Our Ref: EN020032

Application by Morgan Offshore Wind Limited and Morecambe Offshore Windfarm Limited (“the Applicants”) for an Order granting Development Consent for the proposed Morgan and Morecambe Offshore Wind Farms Transmission Assets (“the Proposed Development”)

REQUEST FOR INFORMATION

Figure 1: Nearshore Offshore Cable Route through Fylde MCZ and KP markers

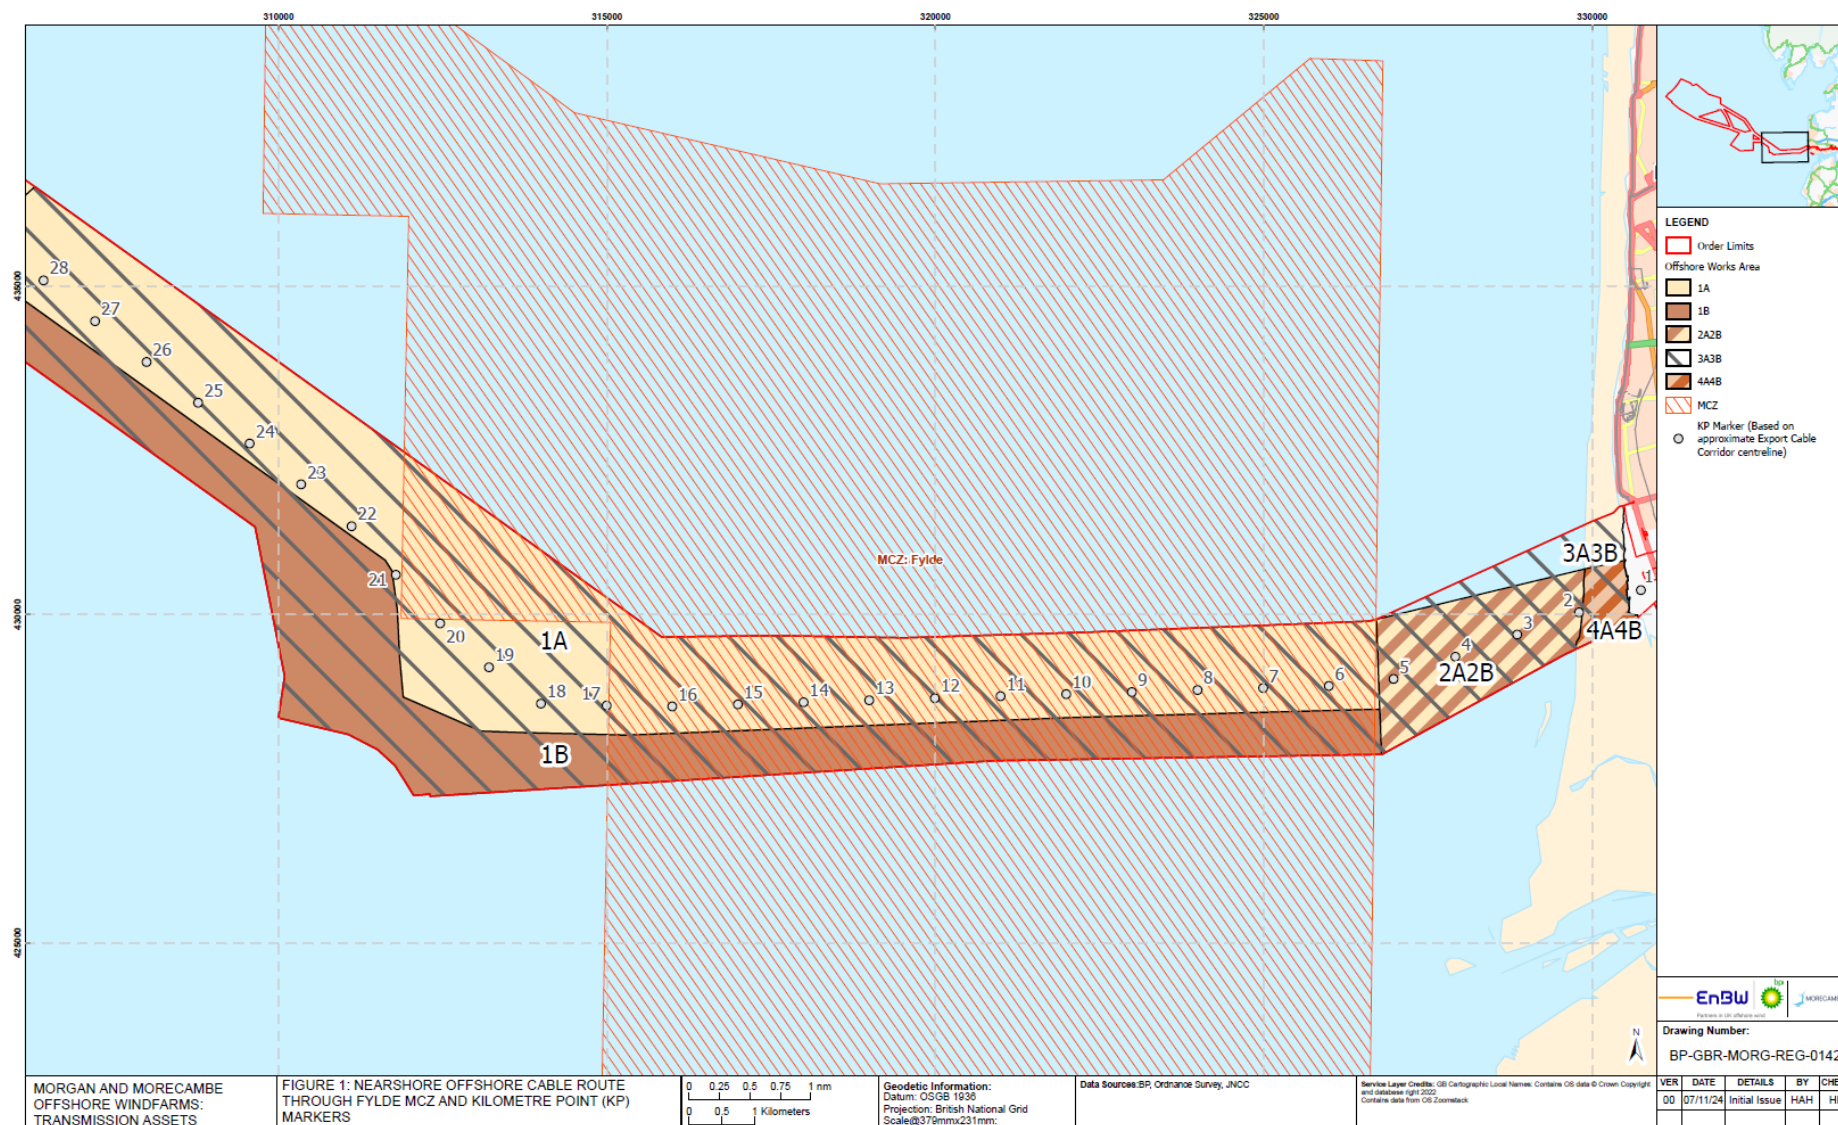
18. The **Applicants** are requested to explain how the 3% MDS for cable protection within the Fylde MCZ (as set out in CoT47 [REP6-042] and the outline Offshore Cable Specification and Installation Plan [REP6-097]) was calculated.

Figure 1: Intertidal and Landfall Works Areas

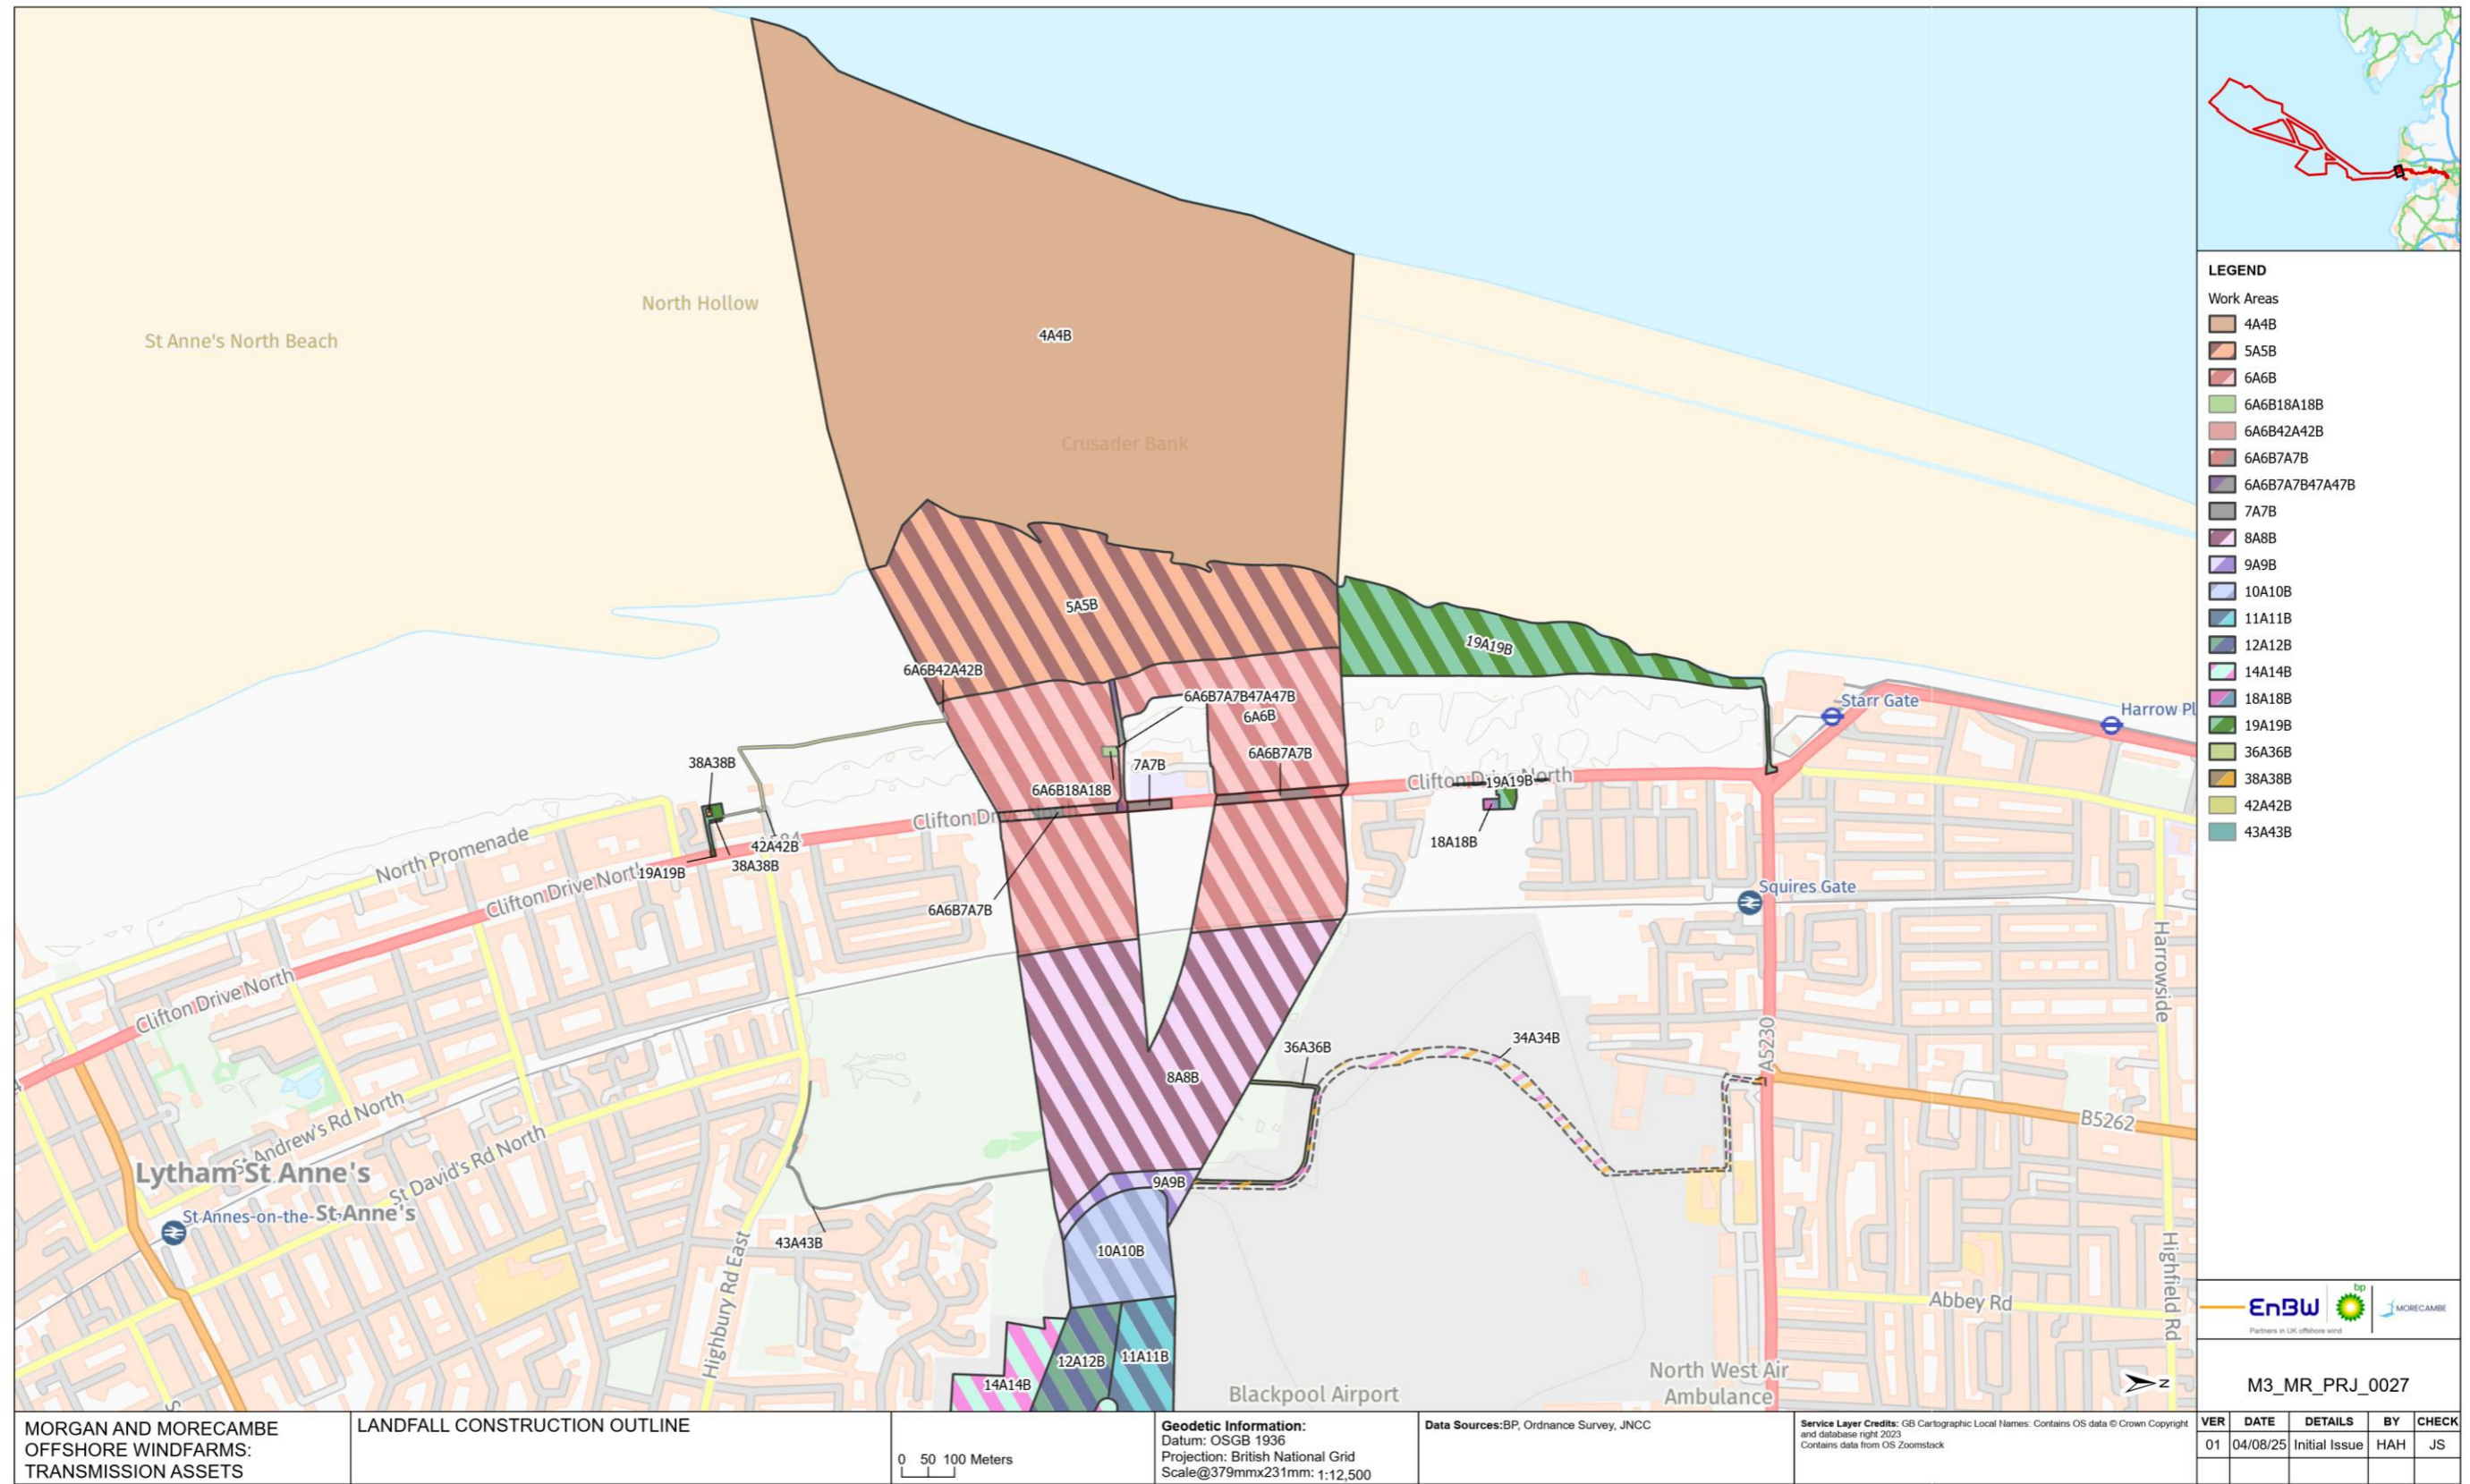
29. The Secretary of State notes Natural England's concern regarding indirect significant impacts on the Lytham St Annes Dunes SSSI from cable installation and advice in its closing statement [REP7-050] that it has not reviewed the Applicants' updated outline Landfall Construction Method Statement [REP6-151]. **Natural England** is invited to comment on the updates and advise whether these resolve their concerns.
